CITY OF ALBUQUERQUE

**Re: 8801 Glendale Blvd NE,
Request for Permanent C.O. –Accepted
Engineer's Stamp dated: 10-8-13, (B20D021)
Certification dated: 12-3-13**

**Re: 8801 Glendale Ave NE, Grading and Drainage Plan
Engineer's Stamp Date 10-8-13 (B20D021)**

**Re: 8801 Glendale Ave NE, Grading and Drainage Plan
Engineer's Stamp Date 10-8-13 (B20D021)**

DRIVEWAY CULVERT SECTION B-B

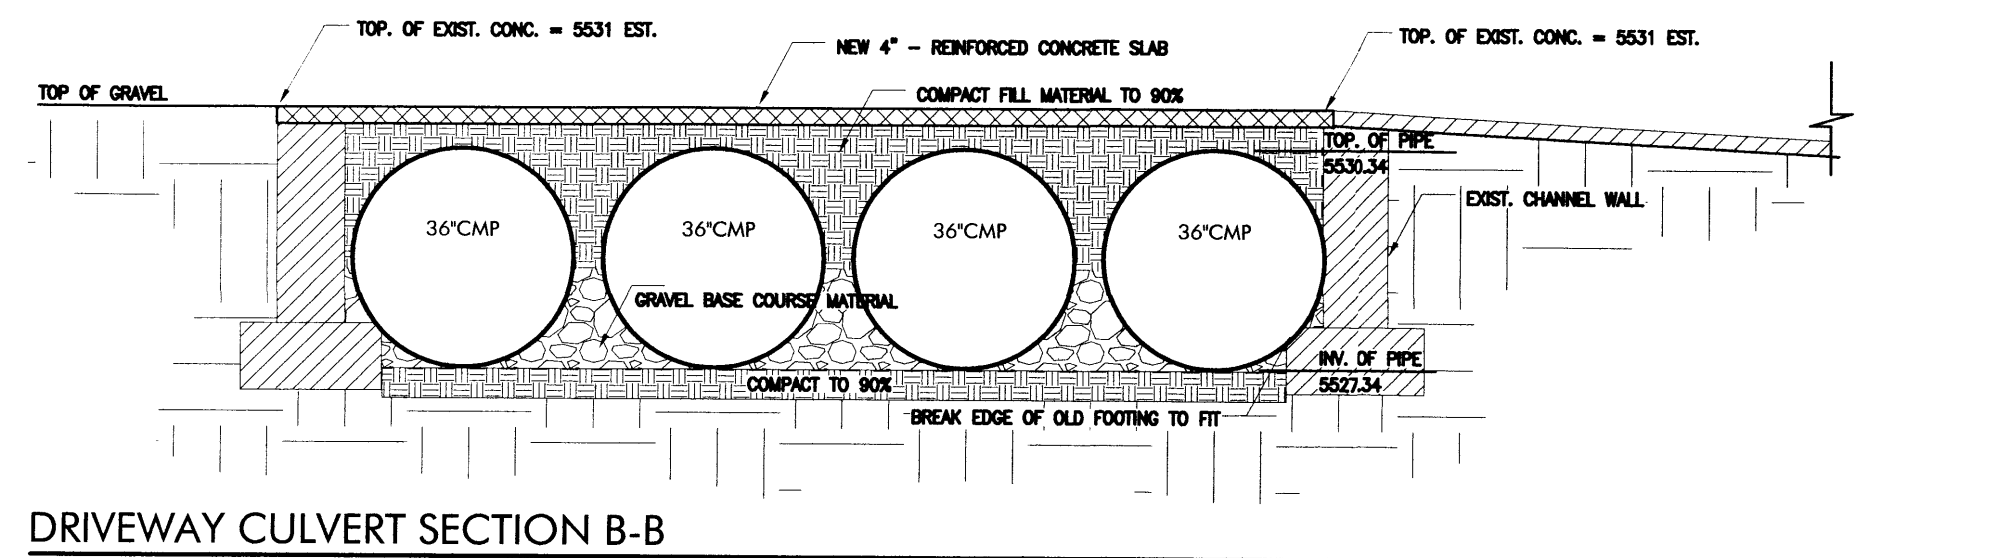
3. A similar condition exists for the headwall along Glendale Ave.
